**WELWYN HATFIELD BOROUGH COUNCIL
ASSISTANT DIRECTOR (PLANNING)**

DELEGATED APPLICATION

Application No: 6/2023/1988/HOUSE
Location: 35 Sherrardspark Road Welwyn Garden City AL8 7JY
Proposal: Erection of single storey rear extension, raising of existing garage roof and insertion of rooflight
Officer: Ms Jessica Fuller

Recommendation: Granted

Drawing No: 5811-P01 Revision: A

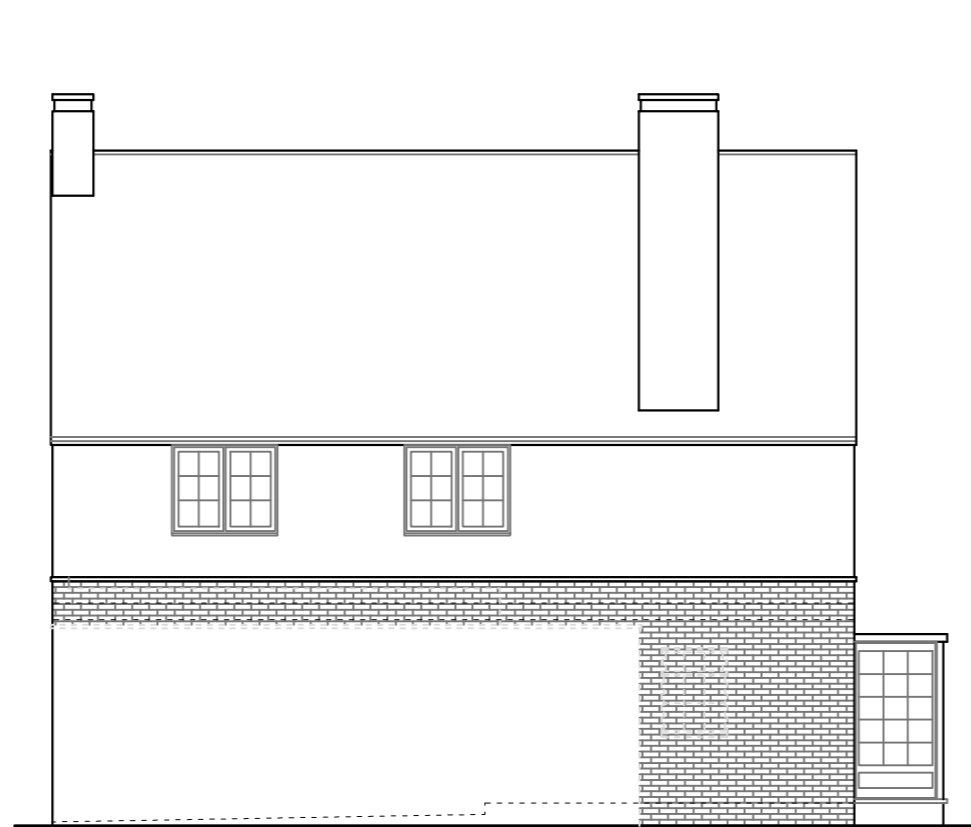
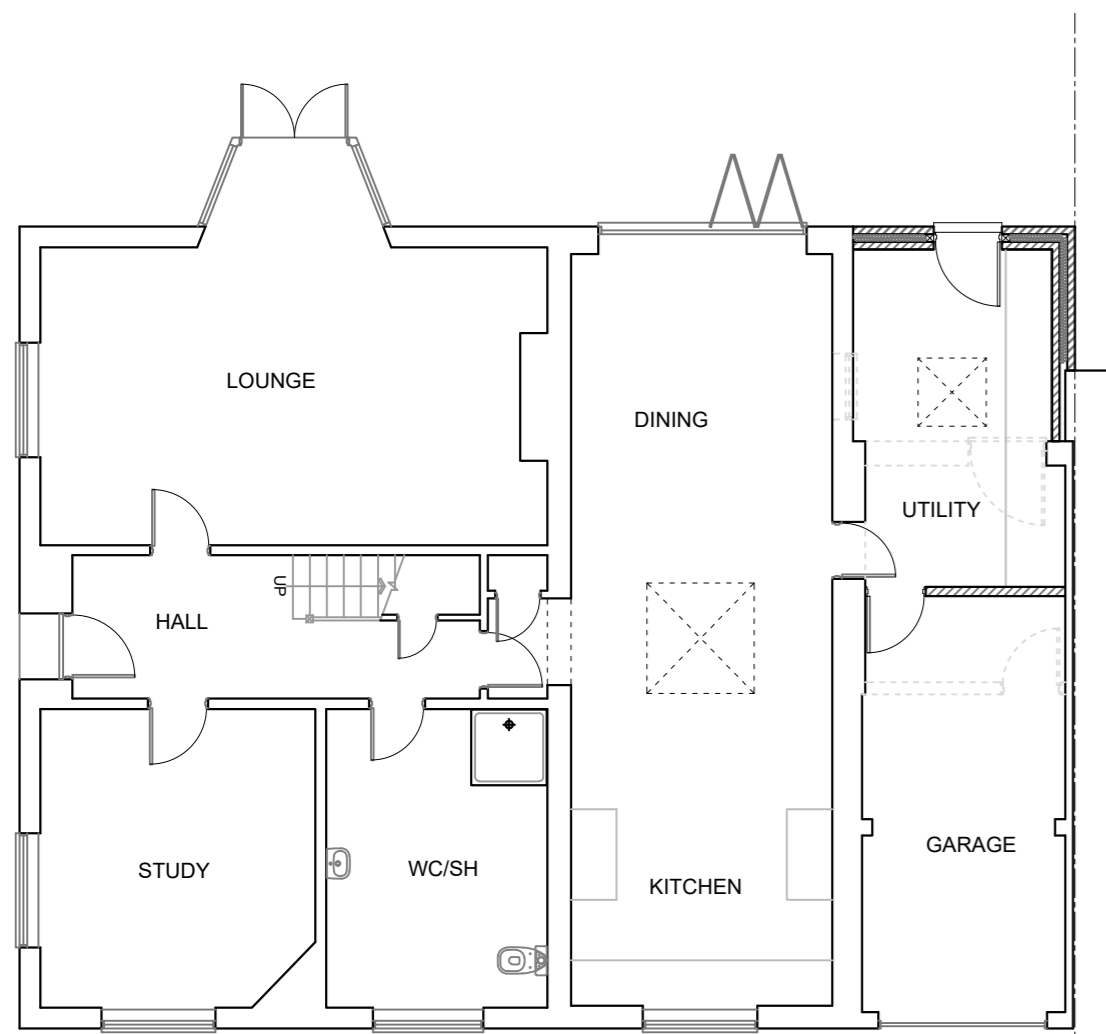
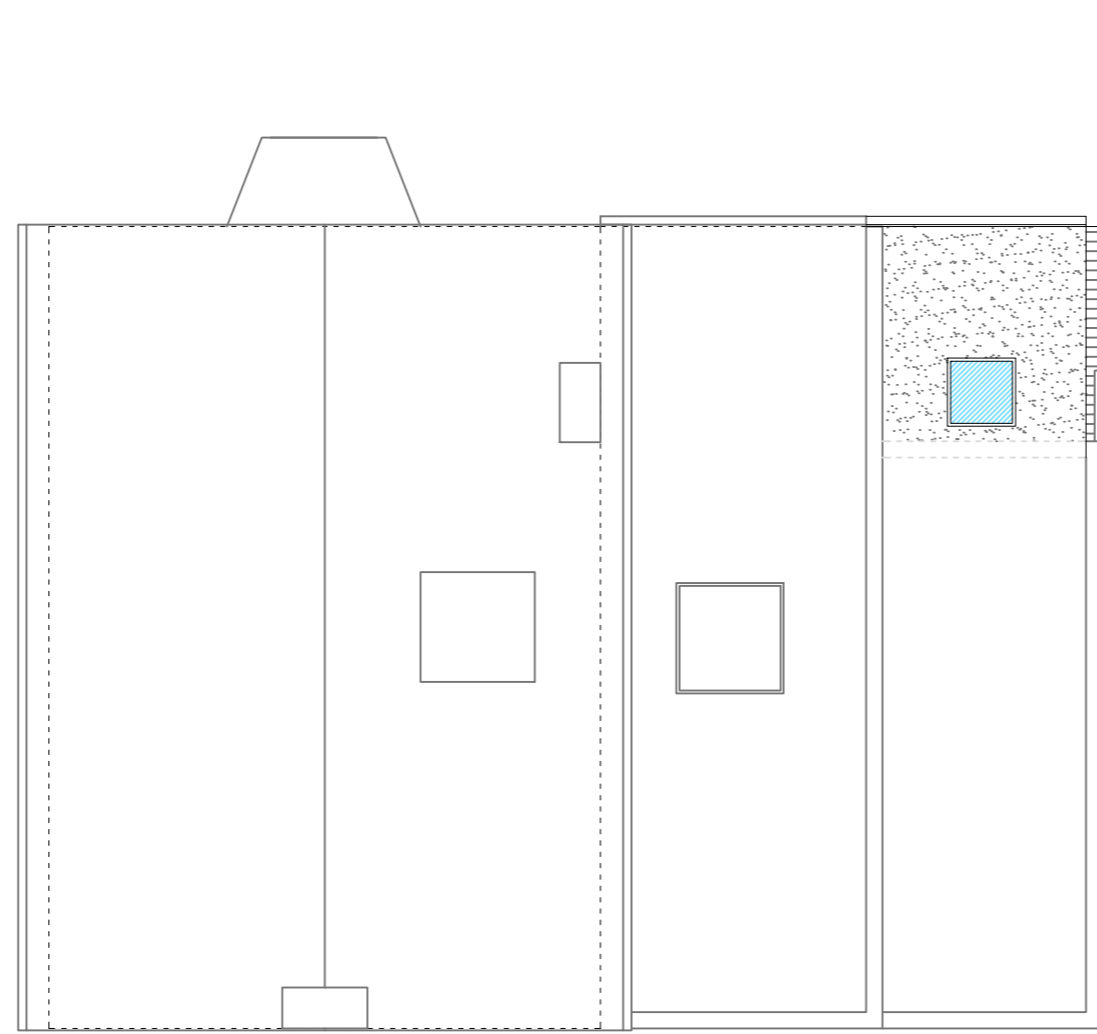
The application seeks planning permission for the erection of a single storey rear extension, raising of the existing garage roof and the insertion of a rooflight. The proposed single storey extension would add approximately 3 metres in depth to the rear of the existing garage, meaning the proposed rear wall would be level with the rear wall of the application dwelling, creating a more complete appearance. This part of the extension would not be unduly visible from key public vantage points

due to its size and location, and as it would be finished with a flat roof it would not result in a detrimental impact on the character of the existing dwelling or surrounding area.

In terms of raising the height of the existing garage roof, the added height of approximately 0.5 metres would reach the same height as the adjoining roof of the kitchen area, also creating a more complete appearance. In light of this, it is considered that the proposal would preserve the character and appearance of the conservation area and reflect the character of the existing dwelling.

The application form states that the development will be finished with facing brickwork, a flat roof and UPVC windows. However, it does not say if these would match existing. The Design and Access Statement suggests that the extension will be constructed using materials to match similar projects nearby. It is noted that the Council's Conservation Officer has recommended a condition for a materials schedule with clear photographs of the types and colour of the materials to be used in the external finish of the development. However, due to the modest nature of the works, it is considered that a condition for matching materials would be more appropriate. This would ensure the development integrates well with the established design of the existing dwelling, as well as properties nearby.

Due to the nature of the proposed single storey rear extension, and minimal addition of approximately 0.5m to the height of the existing garage, it is considered that the living conditions of neighbours would be maintained to an acceptable level in accordance with local and national policy.

1. The brickwork, bond, mortar, windows, detailing, guttering, soffits and other external decorations of the approved extensions and alterations must match the existing dwelling in relation to colour and texture.
